**RE: Moran Development**

This letter includes our responses to comments received from City of Mercer Island regarding the Moran Development project on May 09, 2023. We have reviewed and revised the plan set and associated reports/documents to reflect the changes requested.

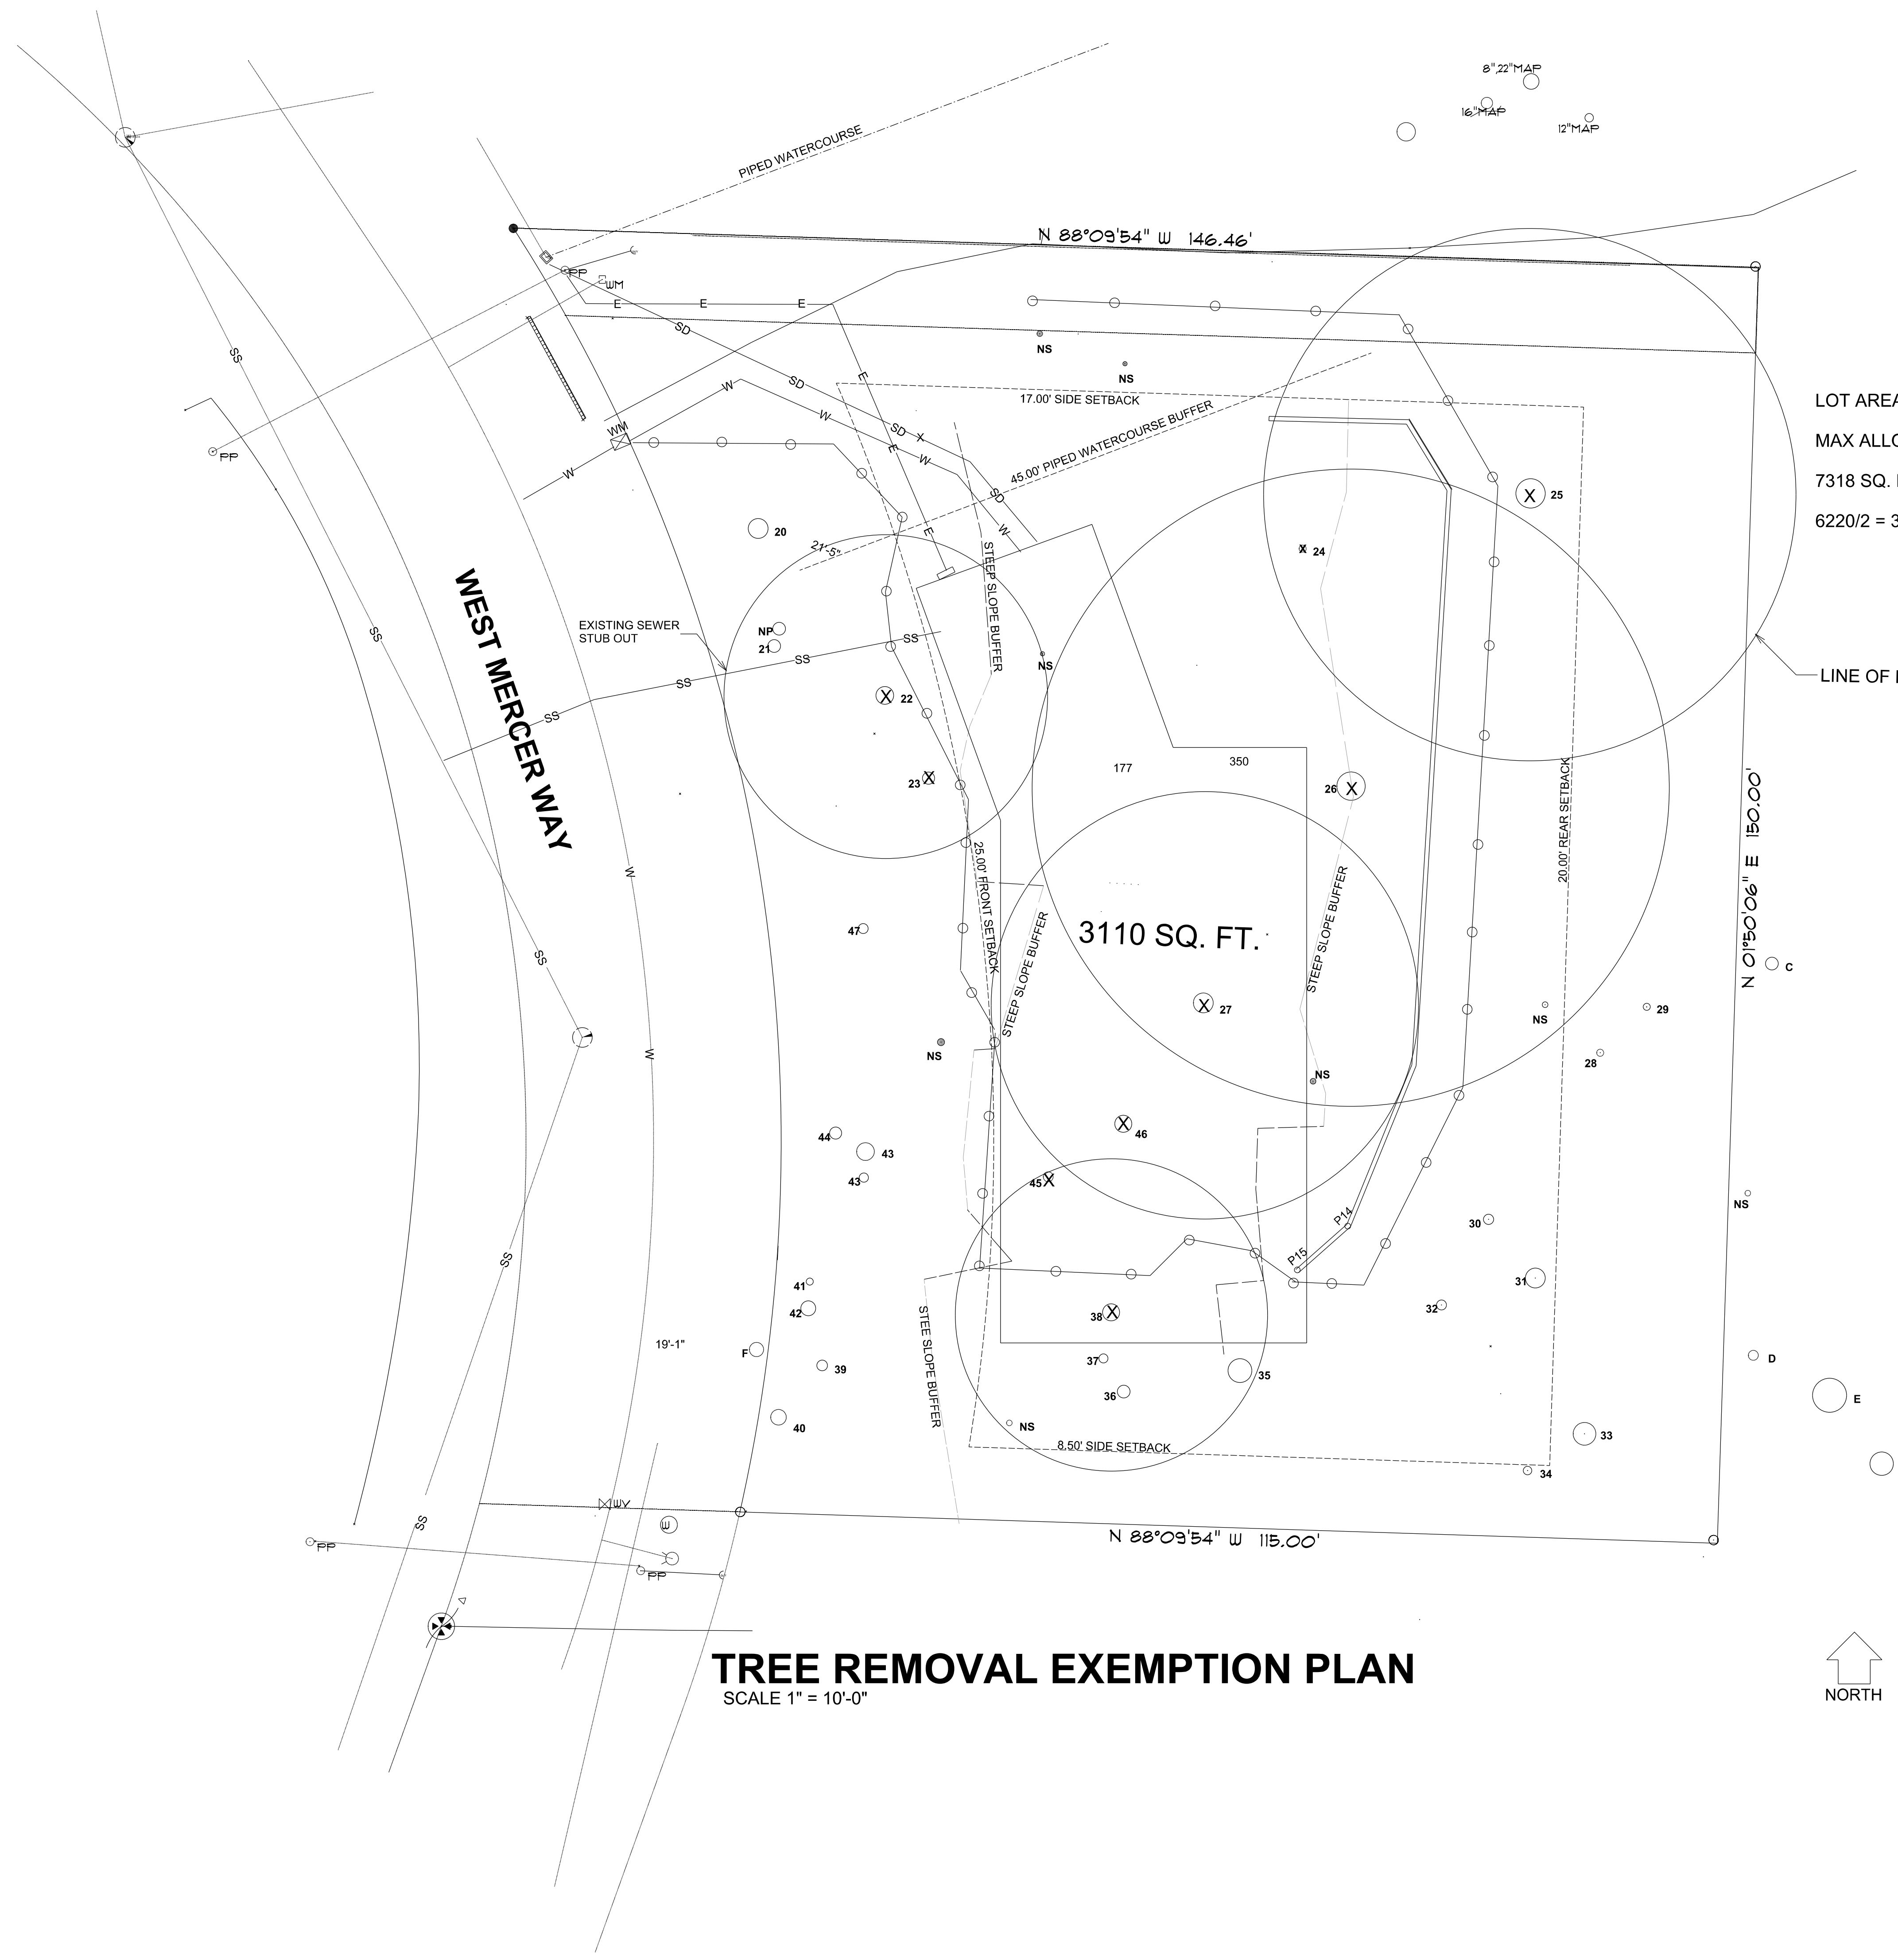
1. Update tree protection plan C4 with distance from tree trunk to the tree protection. This will allow the tree protection fence to be put correctly and to be inspected by city staff. Tree 23 is shown for retention on sheet 15 but shown for removal on C4. This shows the importance of having one civil tree protection plan. Either remove sheet 15 or have it match C4.

Response: Tree Protection Plan has been updated to show distances from the tree trunk, see Sheet C-04.
